8: MEMORANDUM RESPONSE TO SUBMISSIONS RECEIVED

SHADOW FLICKER

Proposed Oatfield Wind Farm Project, Co. Clare: ABP
Case No. ABP-318782-24

Figure 12.1 Receptors and study area (candidate turbine 1)

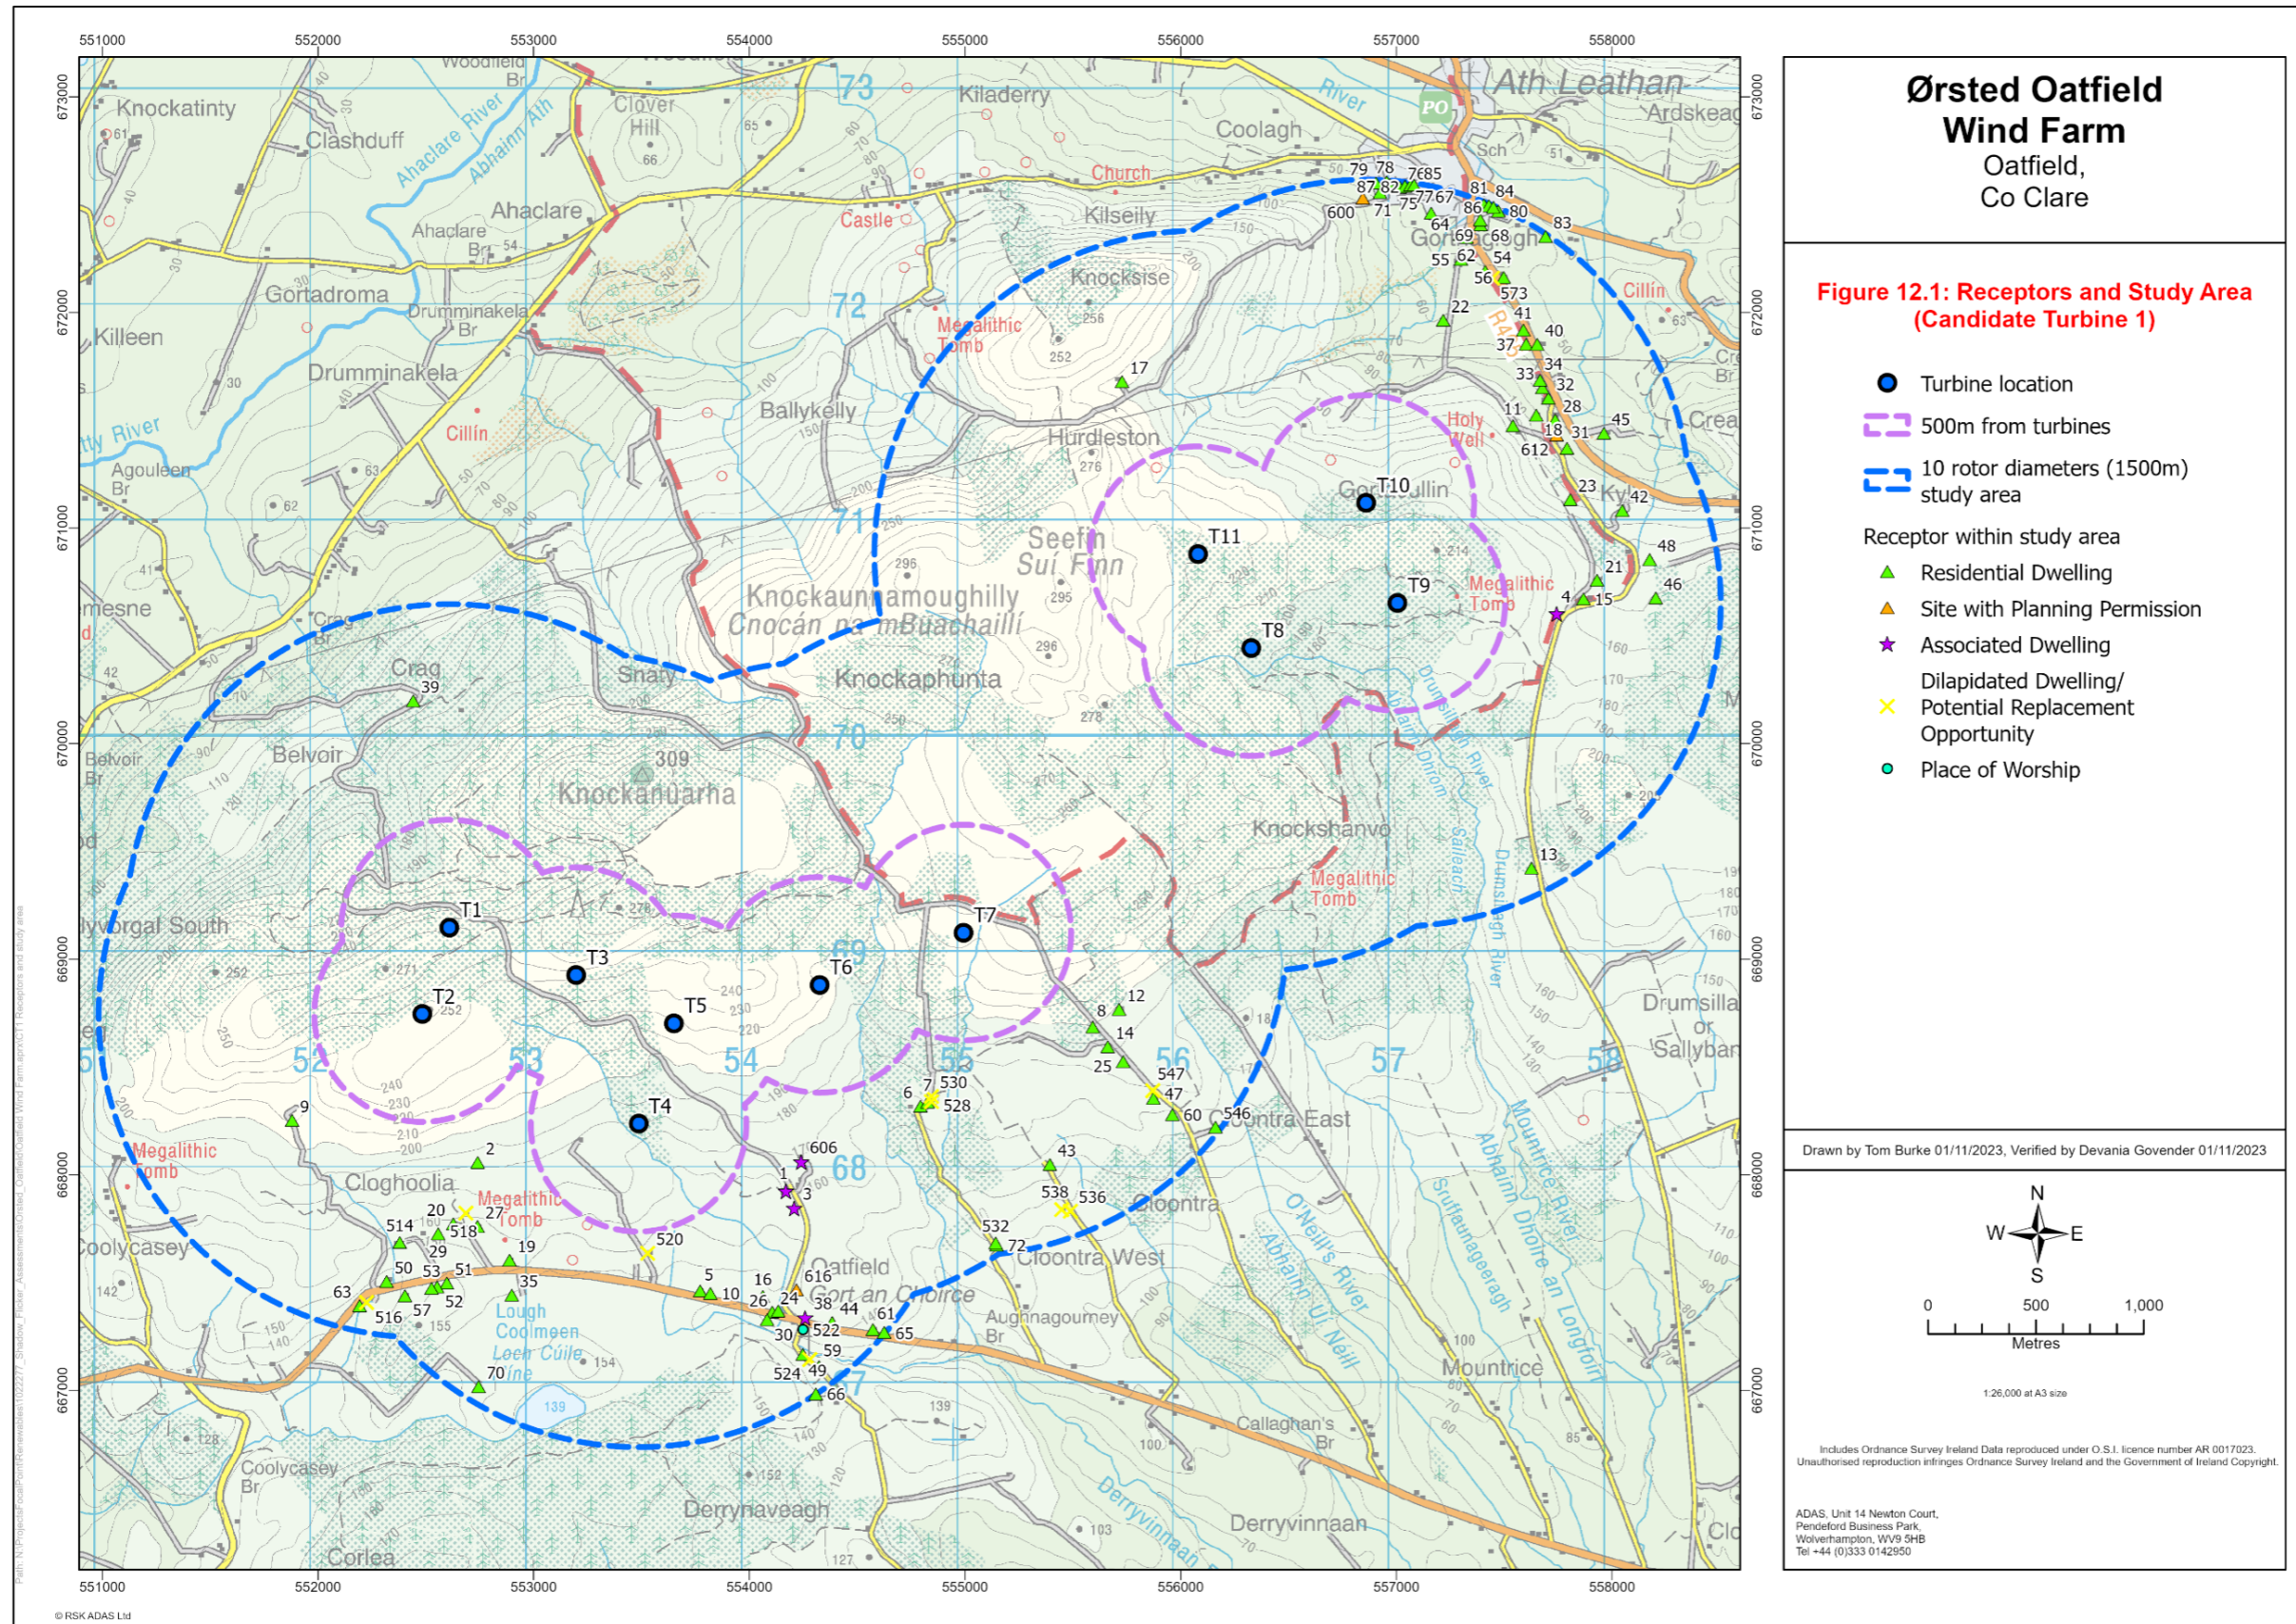
Submissions were received regarding the labelling of some receptors as associated dwellings.

- Receptor 4: Not an involved landowner. Label amended from Associated Dwelling to Residential Dwelling.
- Receptor 520: Involved landowner. Label amended from Dilapidated Dwelling / Potential Replacement Opportunity to Associated Dwelling.
- Receptor 606: Not an involved landowner. Label amended from Associated Dwelling to Residential Dwelling.

Shadow flicker was assessed at all sensitive receptors within the shadow flicker study area, including those labelled as Associated Dwellings in the list of sensitive receptors. This change in labelling therefore does not change the levels of shadow flicker predicted at these receptors, the number of sensitive receptors within the study areas, or the total levels of predicted shadow flicker reported in the assessment. It does, however, impact how these are described within the chapter text and labelled within tables and figures.

- **EIAR Chapter 12**, Figures: 12.1 12.2, 12.3, 12.4, 12.5, 12.6, 12.7, 12.8, 12.9, 12.10
- **EIAR Chapter 12**, Tables: 12.2, 12.3, 12.4, 12.5, 12.6
